Subject: FW: 2018-051 Field House Dewsbury - Planning Comments - 2022/92236

Condition 3 – Windows

Condition 4 – Additional Storey

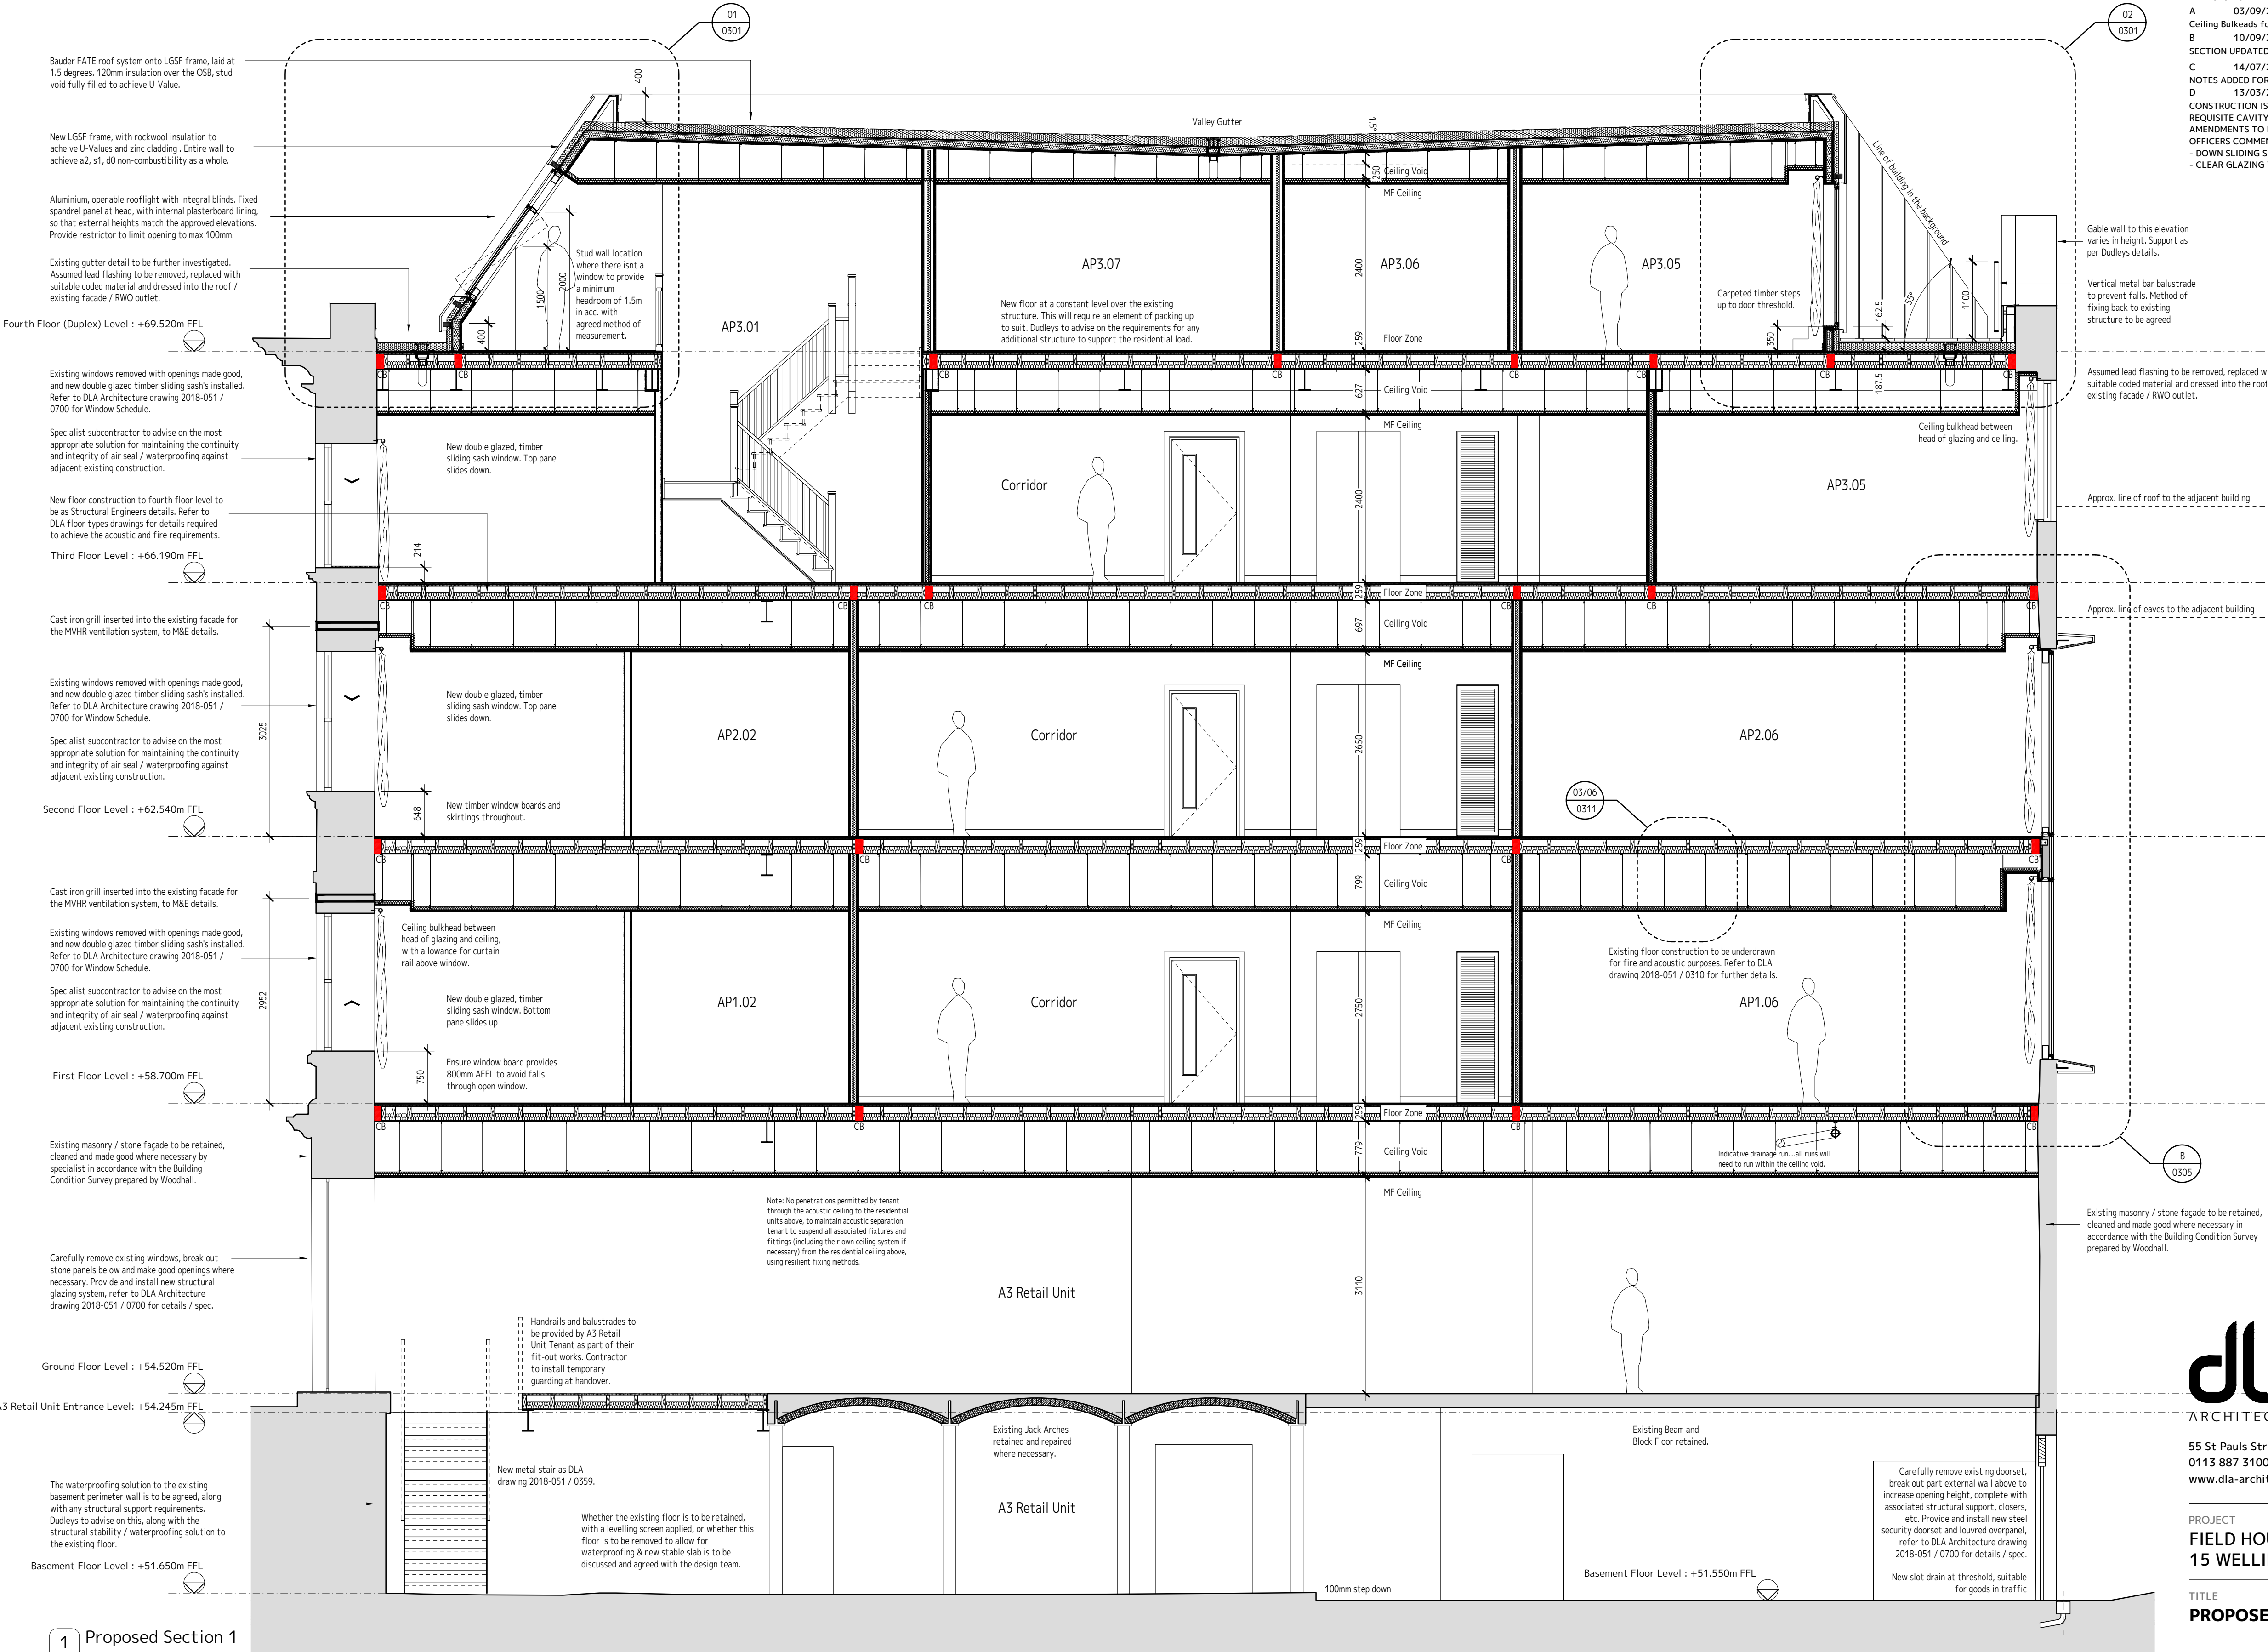
- *Replace all second and third floor windows subject to sufficient justification and that they are replaced as sliding sash windows and subject to submission of further details.*
DLA Comment – Justification for pivot windows with a bottom fixed panel over sash windows was to form compliant guarding with Building Regulations. The existing sills are too low for sash windows and as such, additional guarding would be required. There would still be a potential risk of falling from height and as such, we would advise against in accordance with our CDM Assessment.

I don't feel that the responses in green above address the concerns in my consultation response or meet the requirements of Condition 3. The justification provided for replacing all windows could be achieved by refurbishing and upgrading the existing windows which are in good condition, and introducing draught strips and slim double-glazing which would improve thermal and acoustic performance.

Safety rails could presumably be installed internally, and if the opening lights are below regulation height can the windows incorporate fixed bottom sashes and opening top sashes? This could apply to the top floor where the sashes have been converted to pivot windows to enable true sashes to be fitted at this level, thereby reinstating an historic detail.

Client:-	YMG Construction
Address	Field house - Dewsbury
Tel No	01484 661222
Drawn By	Tom
Scale	1:1
Title	Window Type F1
DWG No.	
Paper	A3
Rev	0

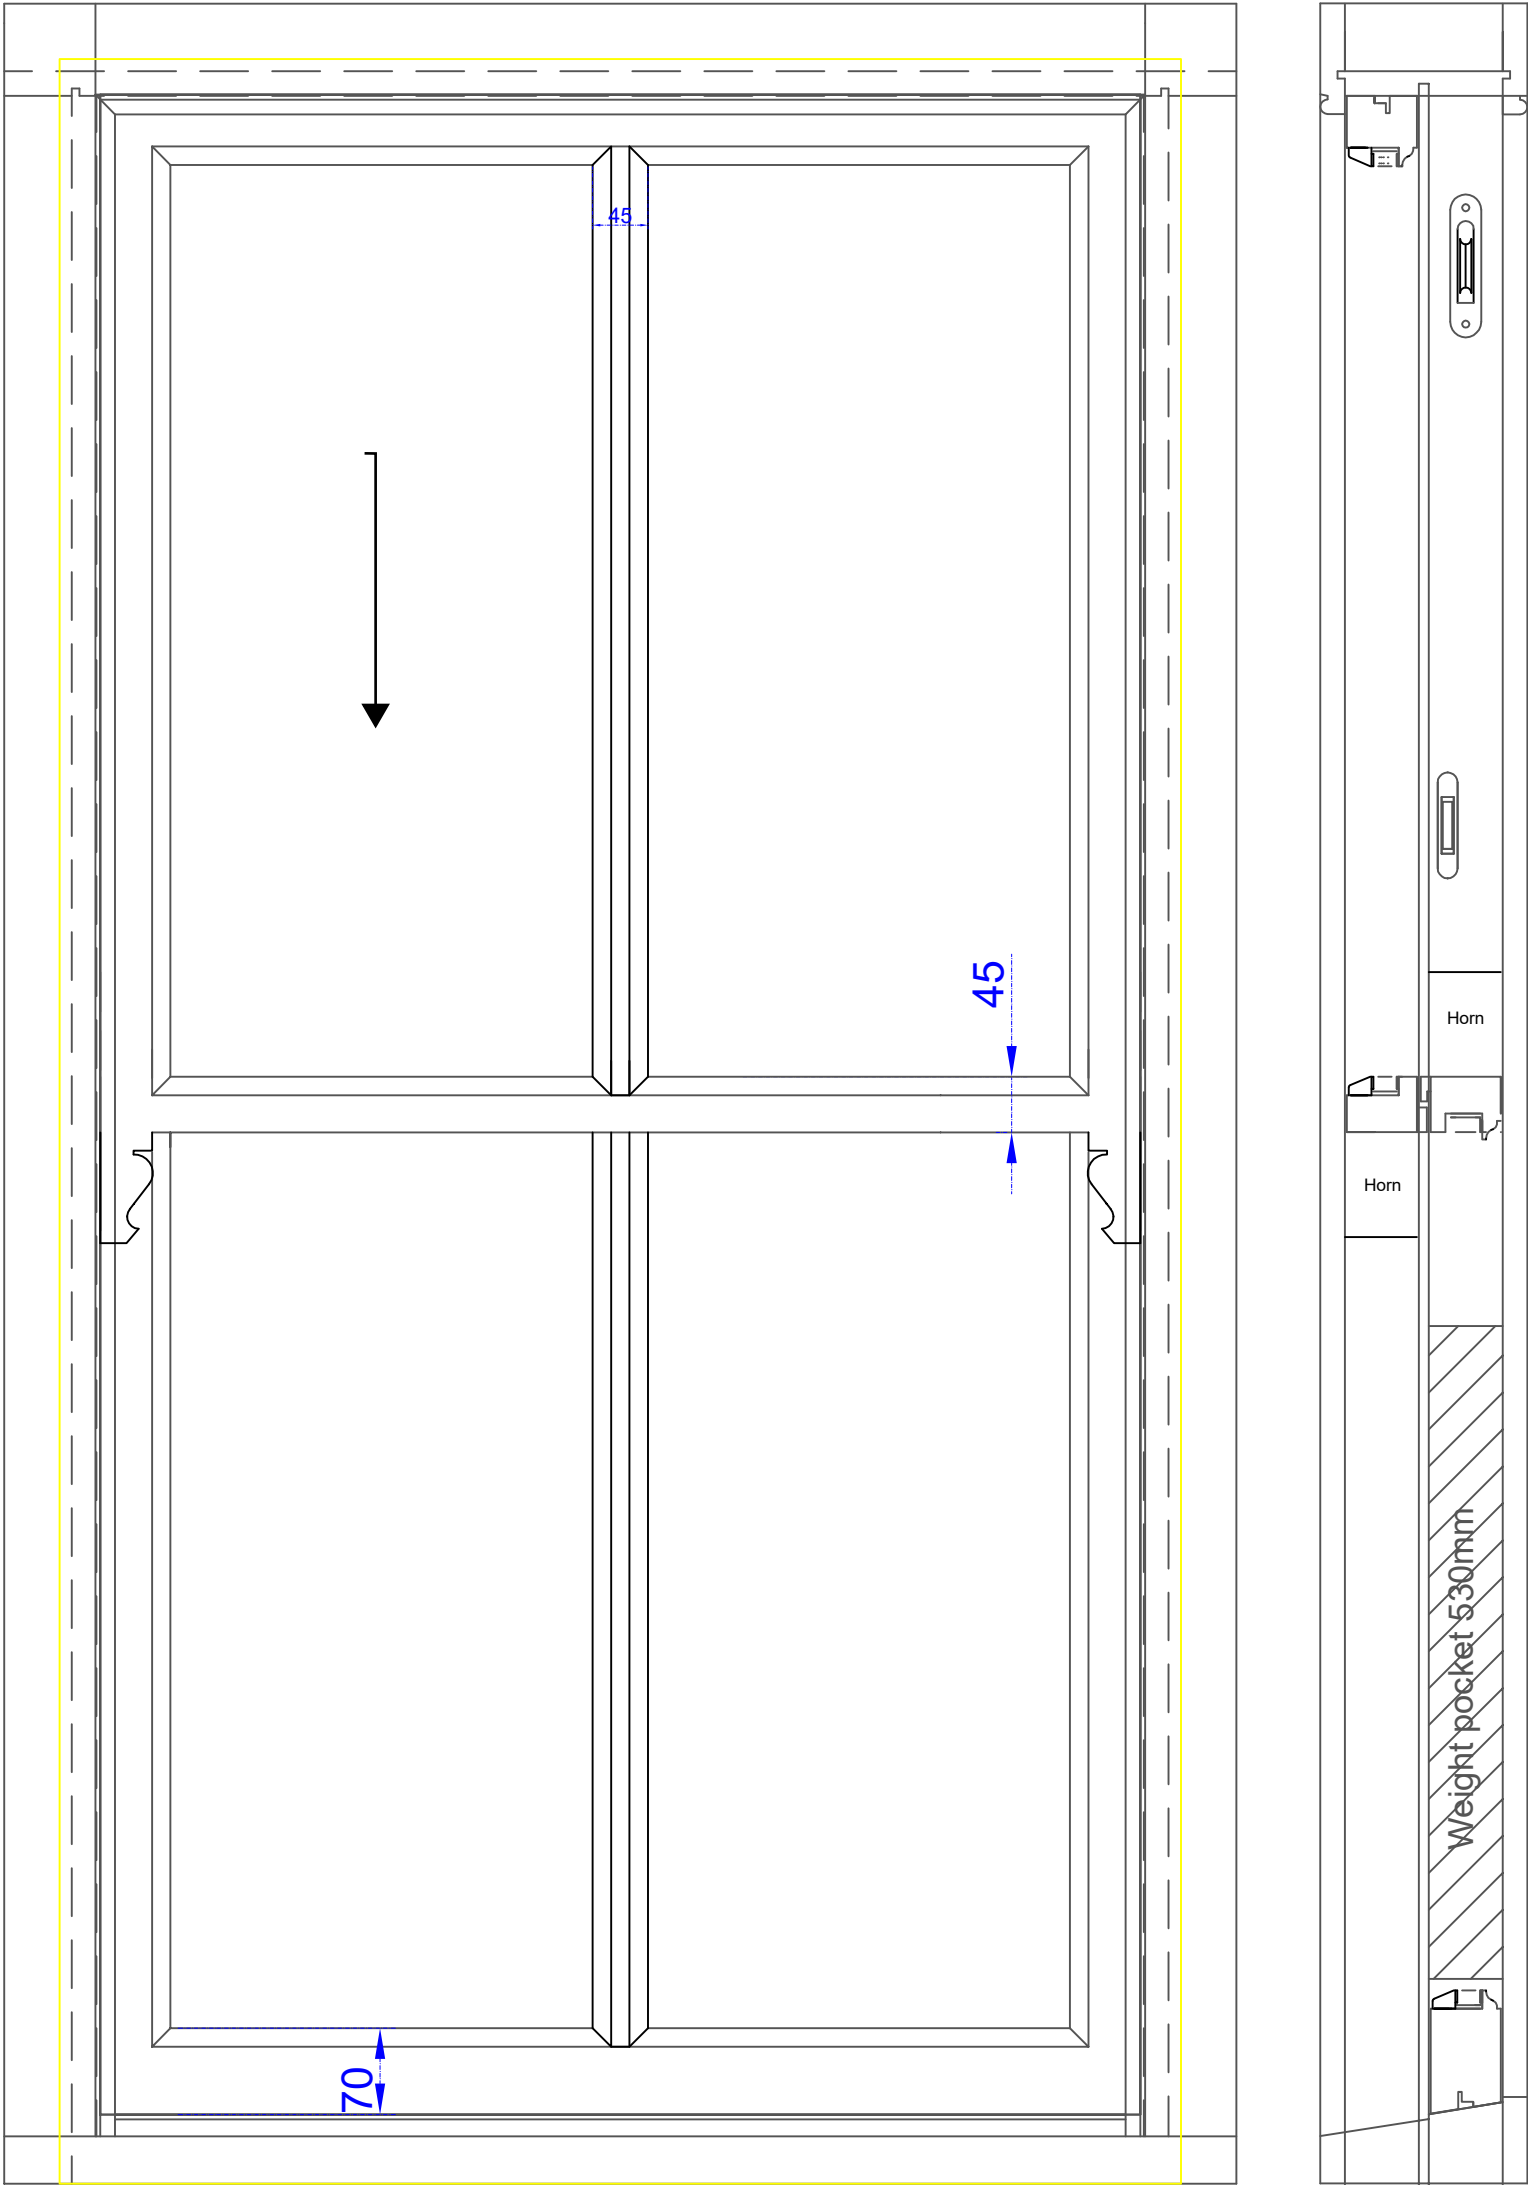
- *Repair all ground and first floor windows (except the frameless windows) in accordance with the Woodhall Condition Survey with the inclusion of slim double glazed units and subject to submission of further details.*
DLA Comment – Justification for replacement windows was on technical grounds. These included requirements for thermal performance, acoustic performance, guarding with safe barrier loading, etc to comply with Building Regulations.
